**Our ref:** RA/2023/145993/01-L01  
**Your ref:** 2023/91491

**Date:** 21 July 2023

**ERECTION OF 61 AGE-RESTRICTED APARTMENTS WITH ANCILLARY ACCOMMODATION INCLUDING SEPARATE RESIDENTS LOUNGE AND MANAGER FACILITIES AND ASSOCIATED EXTERNAL WORKS, INCLUDING THE ERECTION OF ACCESS BRIDGE AND RIVERSIDE WALK FEATURING TWO PEDESTRIAN BRIDGES (WITHIN A CONSERVATION AREA). PRICKLEDEN MILLS, WOODHEAD ROAD, HOLMFIRTH, HD9 2JU**

PROPOSED SITE PLAN

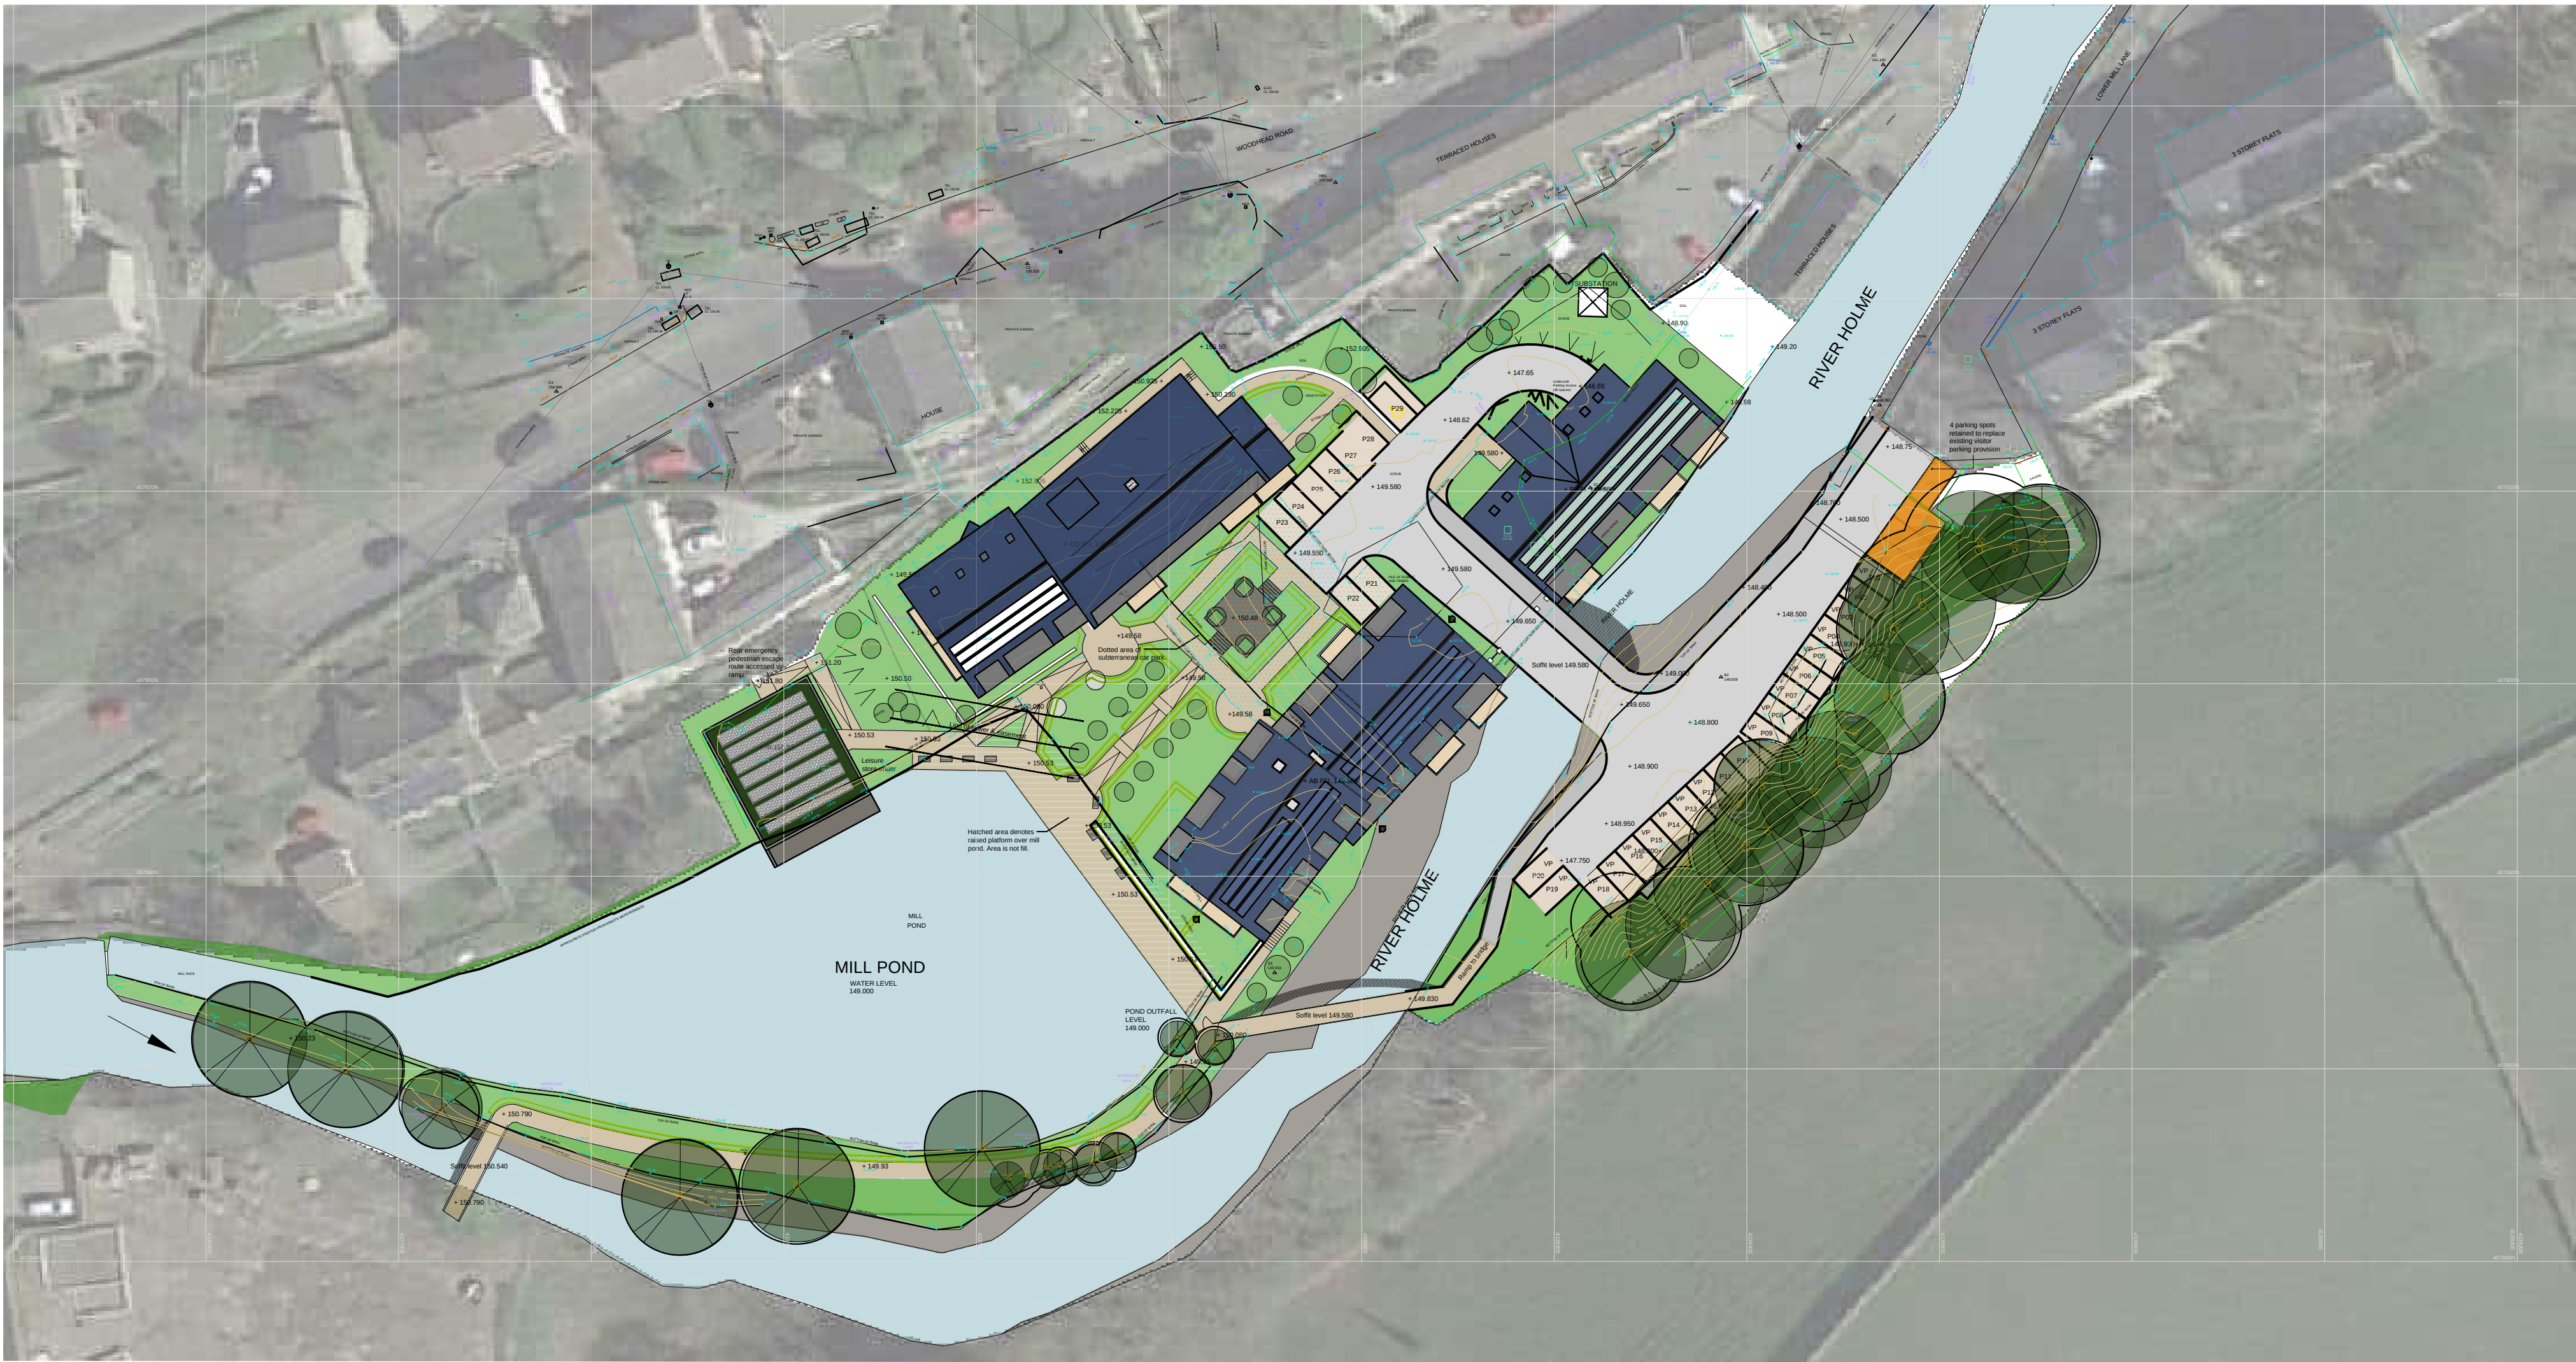
The site plan general arrangement shows a built development on a parcel of land immediately adjacent to, and over, the River Holme. The plans also appear to show new buildings within 8m of the waterbody, structures running parallel to the bank of the River Holme and x2 new bridge crossings. However, it is not clear if the existing river banks (and vegetation) are to be modified or left in-situ, and if modification is proposed, the detail (location & design) has not been provided.

We also recommend that a scheme for the provision and management of, at least, an 8 metre wide undeveloped buffer zone alongside the River Holme waterbody should be submitted to, and approved in writing by, the local planning authority. The buffer zone scheme should be free from all built development, including lighting and domestic gardens. As a minimum, the scheme should include:

We recommend that any proposed bridge crossings are clear-span (i.e. have no in-channel supports) and have abutments that are sufficiently set-back from the river bank.

To overcome this objection, we request additional information is provided on the proposed development – specifically, information relating to the proximity of any built development to the River Holme and any proposals relating to the modification of the river bed and/or banks.
